**From:** Carmichael Ian <Ian.Carmichael@thamesvalley.pnn.police.uk>  
**Sent:** 09 July 2020 07:30  
**To:** Linda Griffiths  
**Cc:** Planning  
**Subject:** Planning ref: 19/00895/REM (FURTHER AMENDMENTS). OS Parcels 6741 and 5426 West of Cricket Field and North of Wykham Lane Bodicote.

**Planning ref: 19/00895/REM (FURTHER AMENDMENTS). OS Parcels 6741 and 5426 West of Cricket Field and North of Wykham Lane Bodicote.**

DRAWING
 Garage Planning Drawing
 Dual Branded Garage: LDG2H8
 Floorplans - Sheet 1 of 2

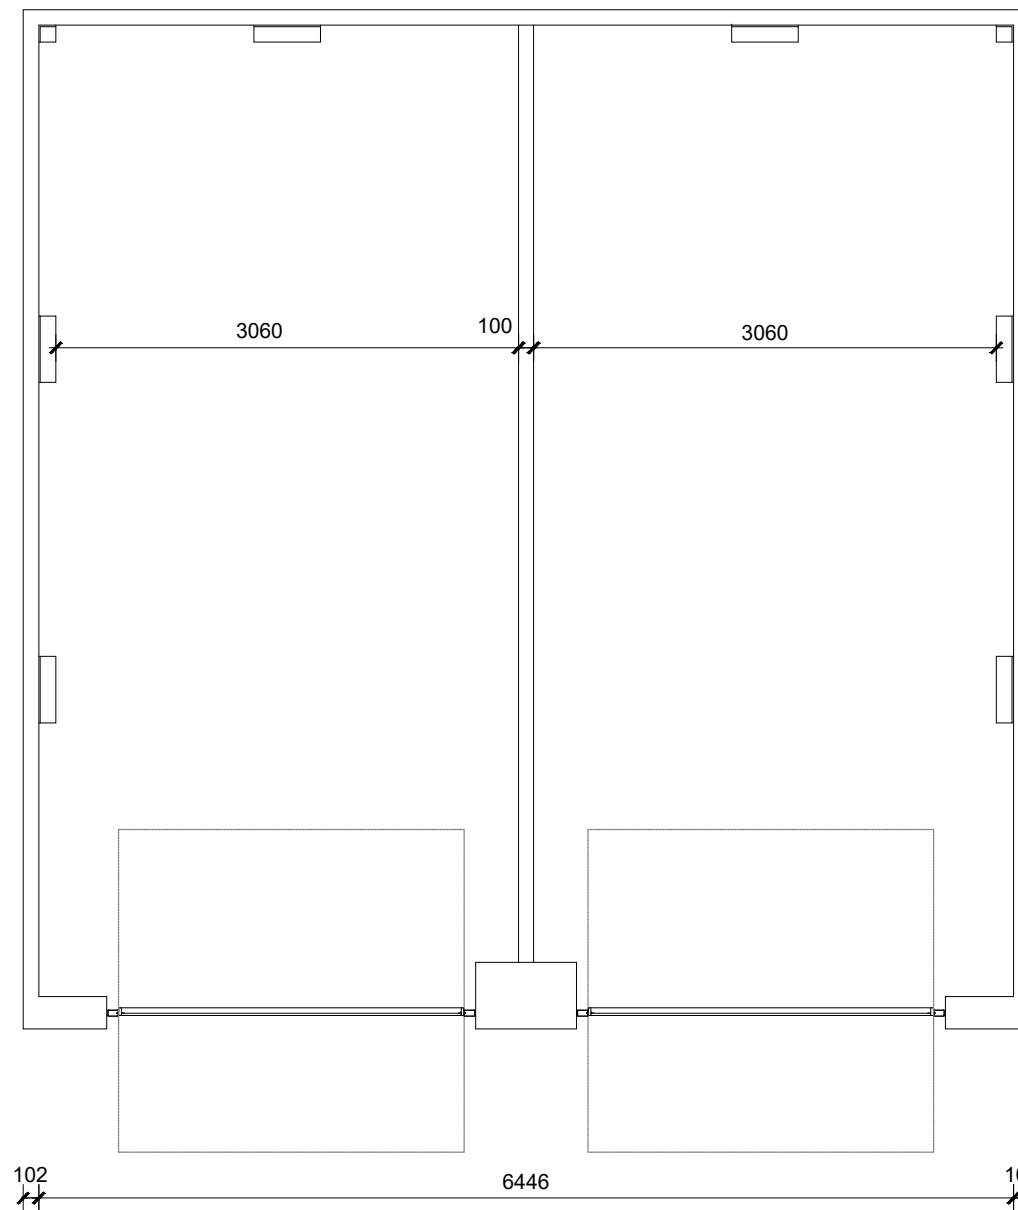
One difference I do note from the amended documents, but am rather confused by is the addition of car ports. I reviewed the plans for these features but could not find the indicated location on any of the site plans. I assume that this is a mistake and that car ports will not form part of these proposals. However, if they do (and amended site plans are supplied showing their location), they should be lit using a switched photoelectric cell unit, be overlooked from active rooms of adjacent properties and be gated. Ideally, I would prefer to see garages provided instead because car ports can be problematic as they are unsecured, create hiding places and make vehicles, property and people vulnerable.

Drawing Title
HARD, BOUNDARY & FURNITURE PROPOSALS (SHEET 2 OF 3)

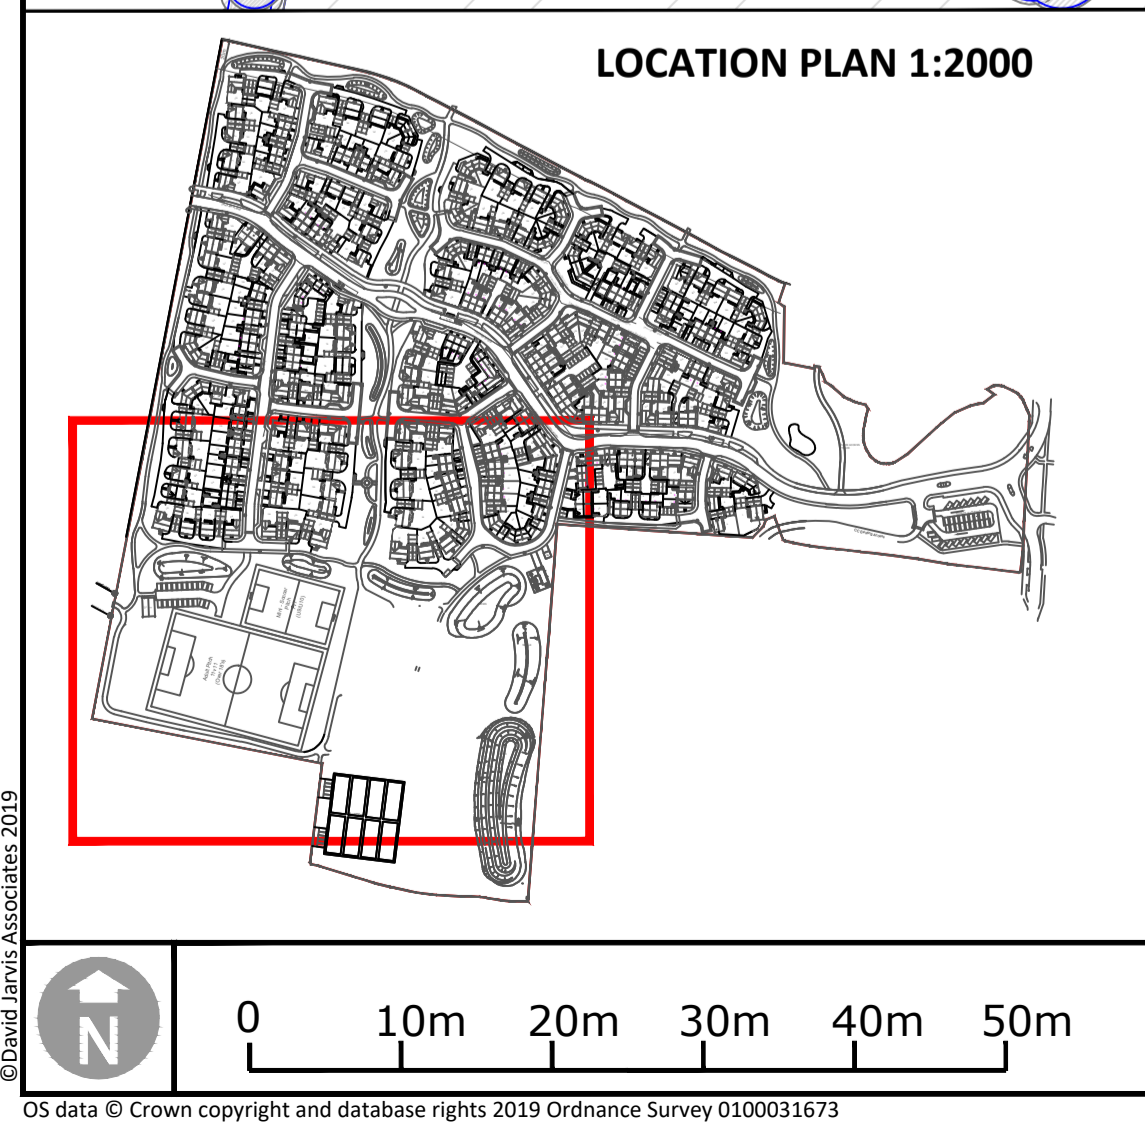
- Despite there now being more parking courts making additional rear gardens of dwellings vulnerable, advice on the specification of boundary treatments has not been taken on board.

- In addition, some rear garden gates have still not been moved forward to the front building line when they easily could be.
- Advice relating to car ports also appears to have been disregarded.

- Where boundary treatments of private rear gardens abut public or semi-private space they should incorporate features that make them difficult to climb; trellis on fences, angled or rounded copings on walls etc. All access gates to rear gardens (including communal ones) should be; robust, of the same height as boundary treatments, self-closing, have anti-lift hinges and be key operated from both sides. Also, some gates to rear gardens are not provided as close to the front building line as possible, which creates problematic recesses. I would like to see them brought forward wherever possible. And, I note that the DAS states that 'Hit and miss' fencing will be used to provide oversight of parking to the rear of properties. However, the Enclosure Plan shows no such fencing. The proposed visually permeable treatment should be used where possible and appropriate.
